Project Title: LUNA RESIDENCE Building Permit #: _____ City Drainage #: E100028
DRB#: _____ EPC#: _____ Work Order#: _____
Legal Description: LOT7 BLOCK 11 VOLCANO CLIFFS UNIT 5
City Address: 6315 CASA BLANCA DR NW

From: Rael, Rudy E.
Sent: Thursday, September 29, 2016 1:34 PM
To: 'David Soule (david@riograndeengineering.com)'
Subject: Luna Residence SAD 227

Based upon the information provided in your submittal received 9/13/16, the above referenced Grading and Drainage plan dated 9/9/16 cannot be approved for Grading Permit or Building Permit until the following comments are addressed:

LOT 7, BLOCK 11 UNIT 5 VOLCANO CLIFFS SUBDIVISION	DRAWN BY JDG
	GRADING AND DRAINAGE PLAN	DATE 09-11-2016
	1606 CENTRAL AVENUE SE SUITE 201 ALBUQUERQUE, NM 87106 (505) 872-0999	SHEET # 1 OF 1
		JOB #

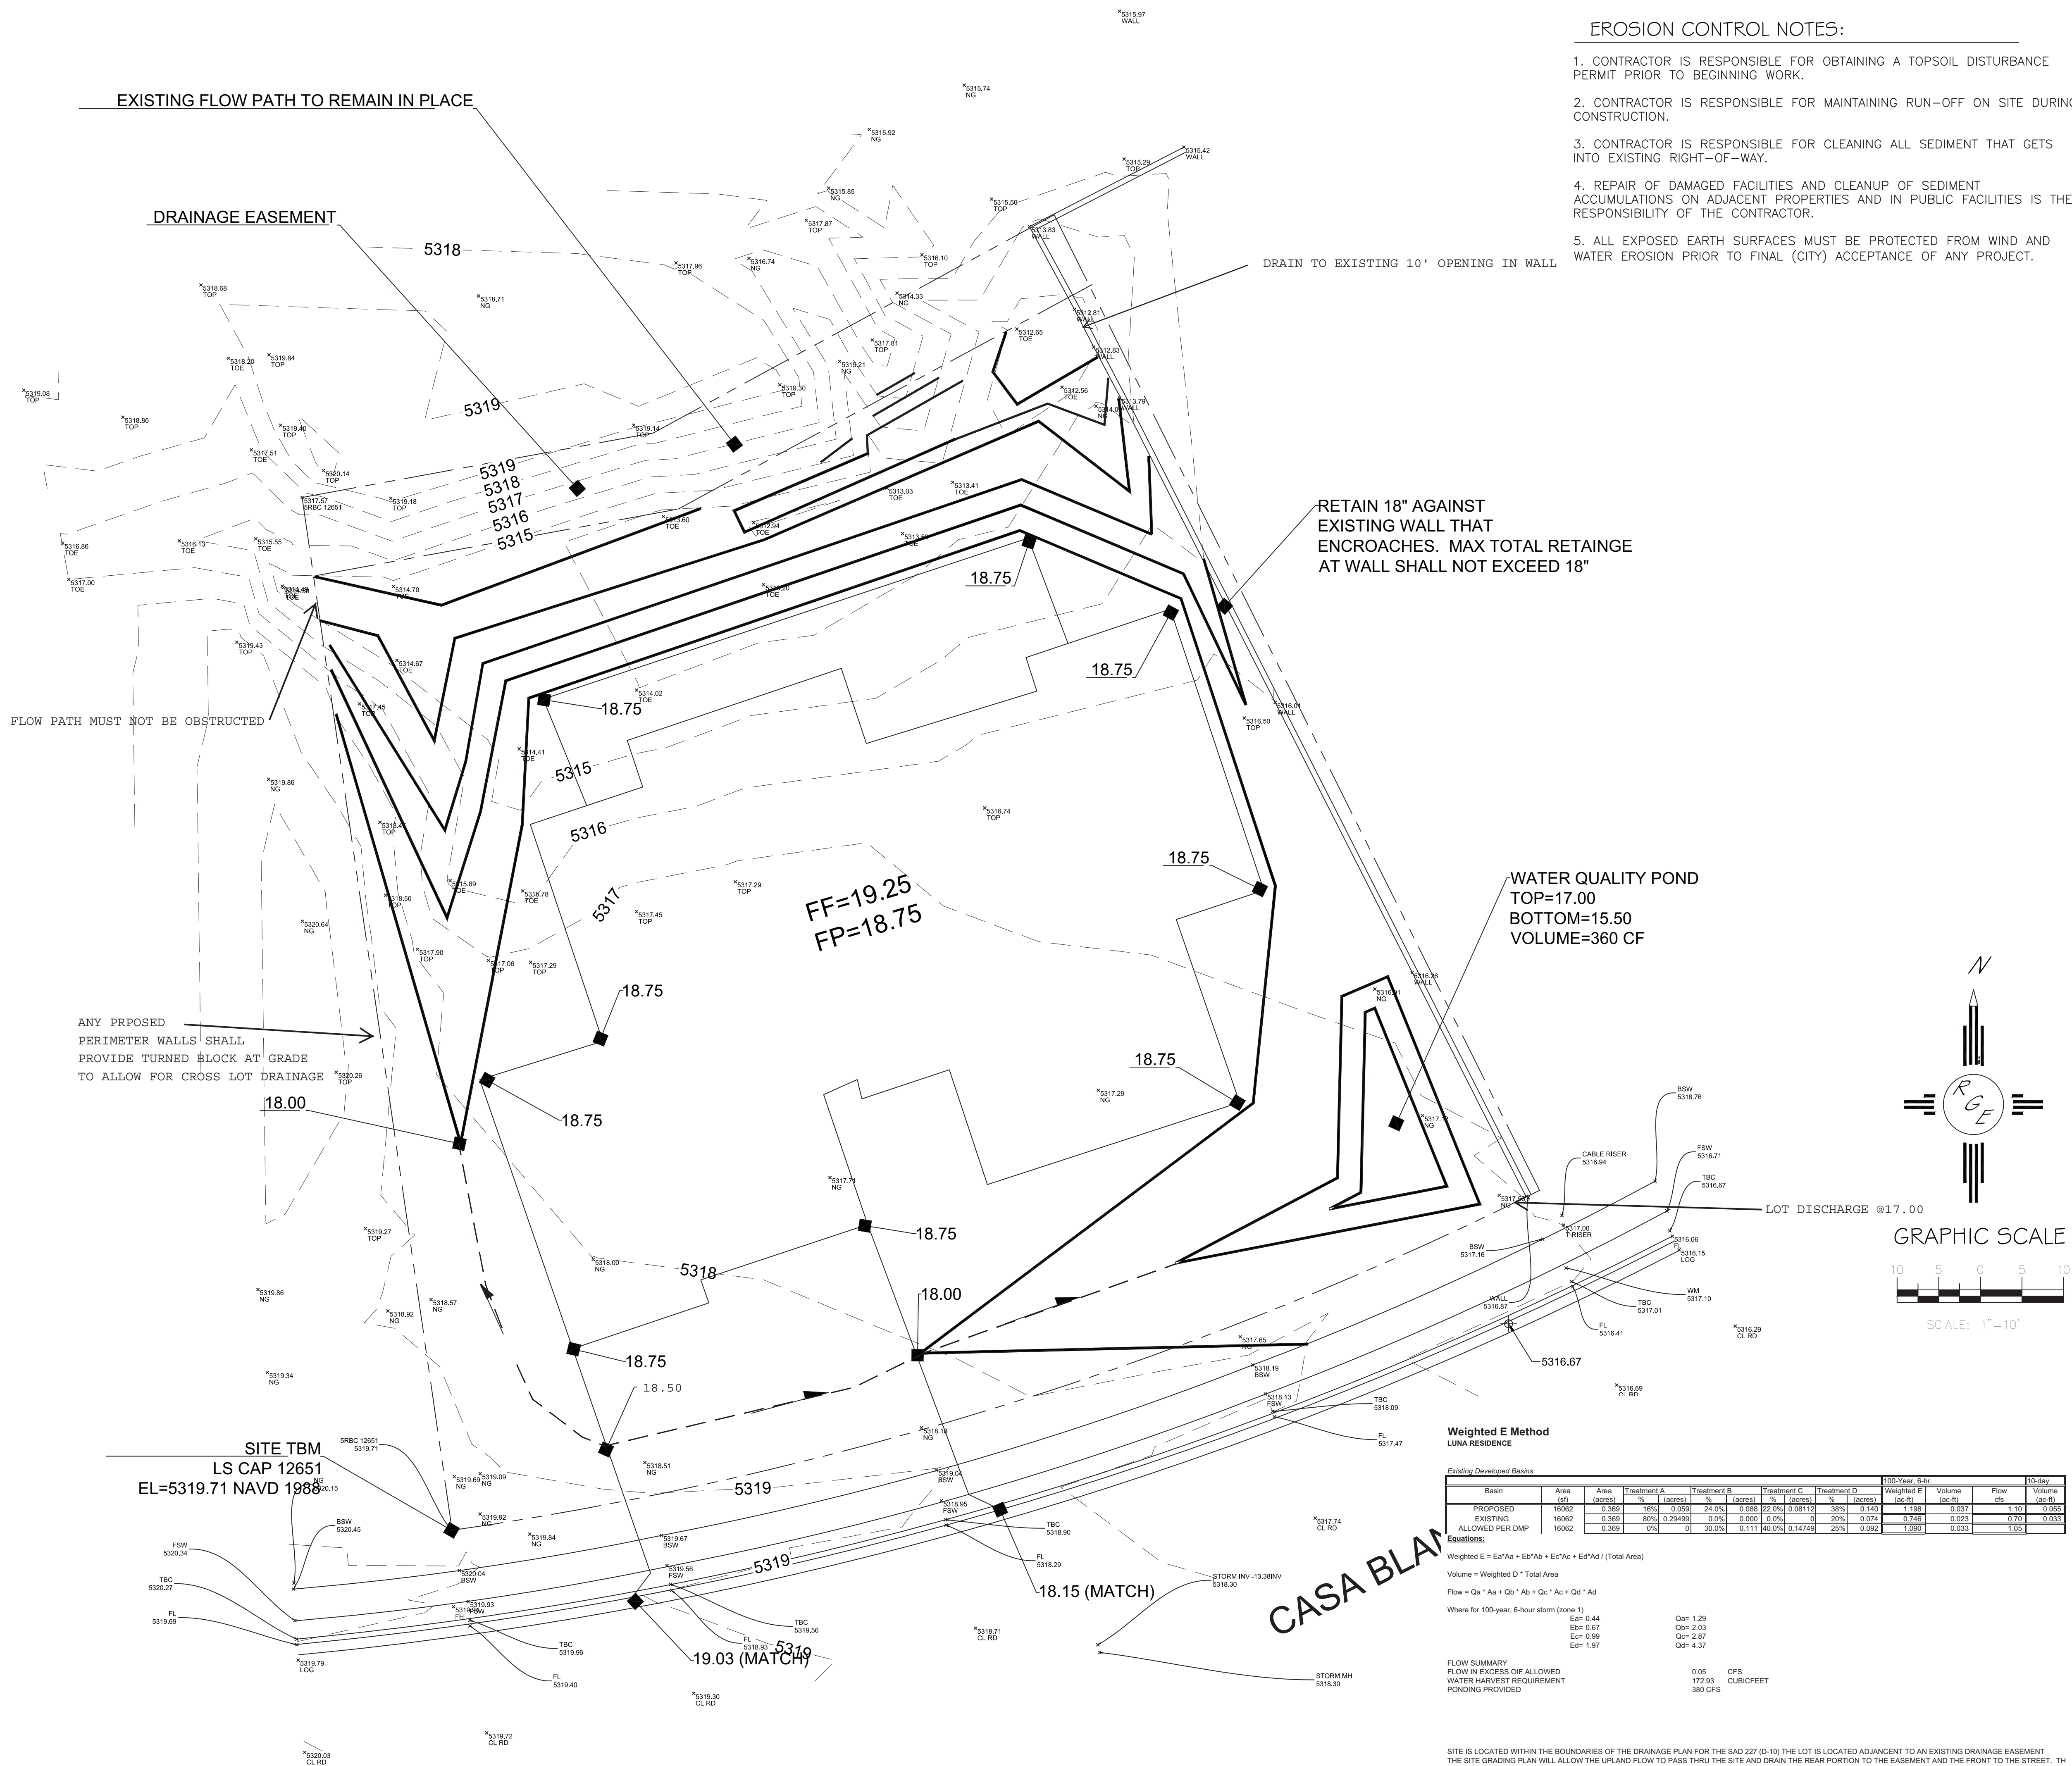
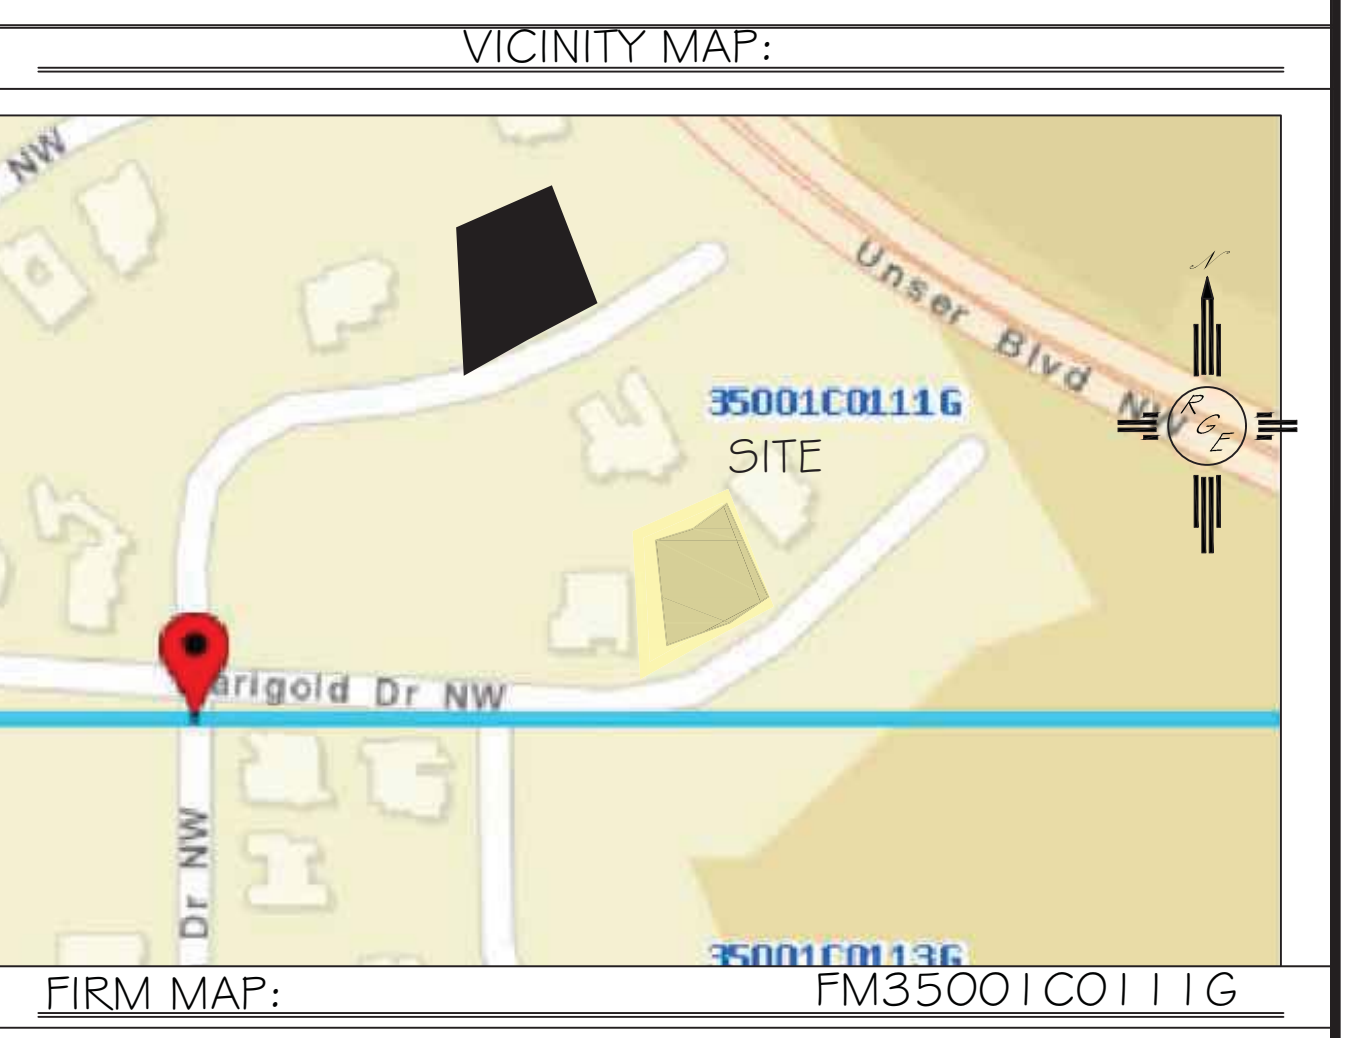
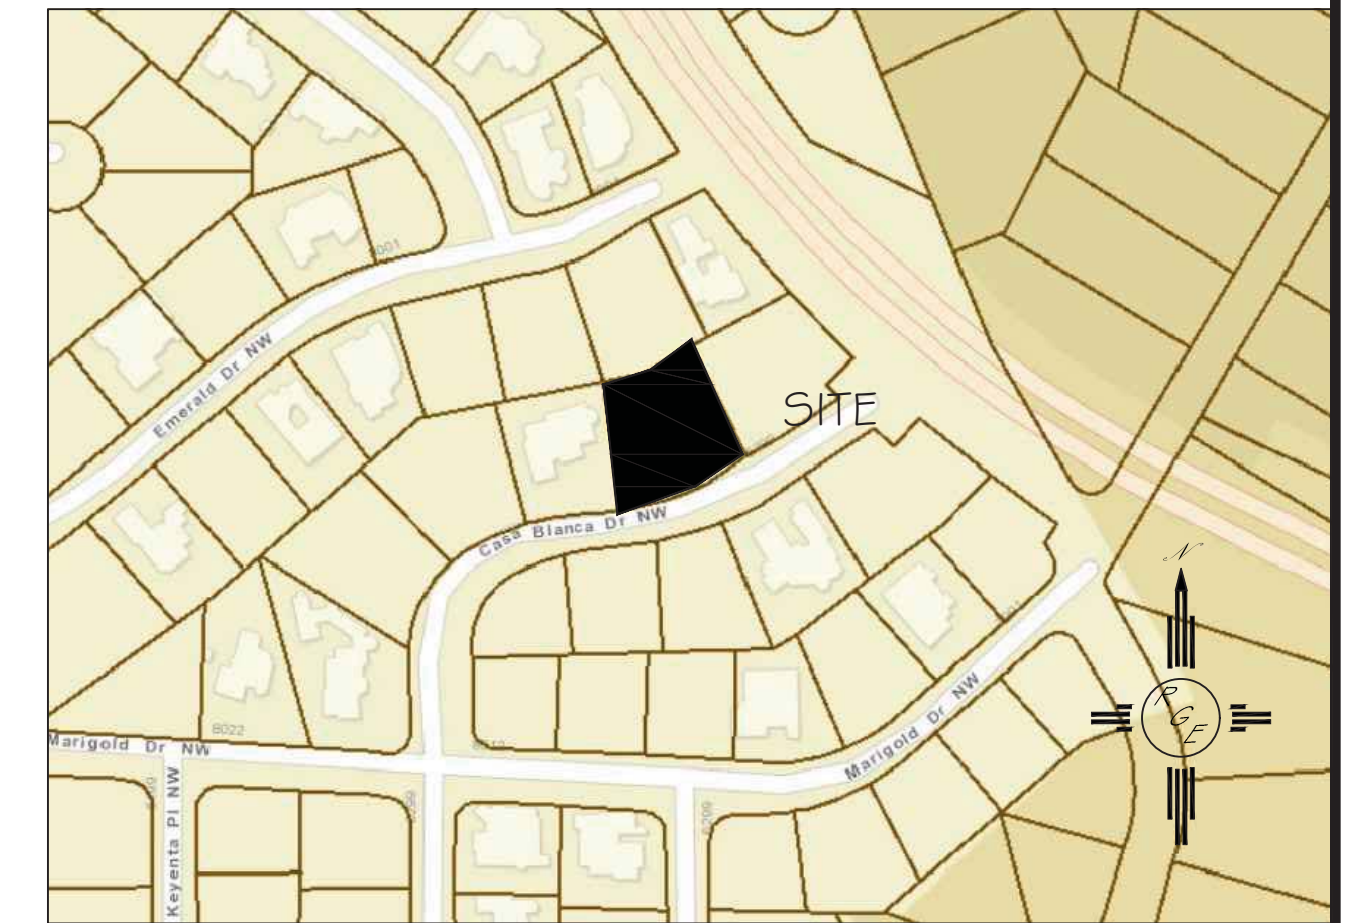
- Enlarge the drainage calcs or provide on a separate sheet with the proper font size. Once submitted the calculations will be checked.
- Add a note stating that a Pad Certification will be required before the pouring of the concrete pad and that all work will be stopped until hydrology has approved the pad elevation. Also add that an inspection for CO from hydrology is a requirement.
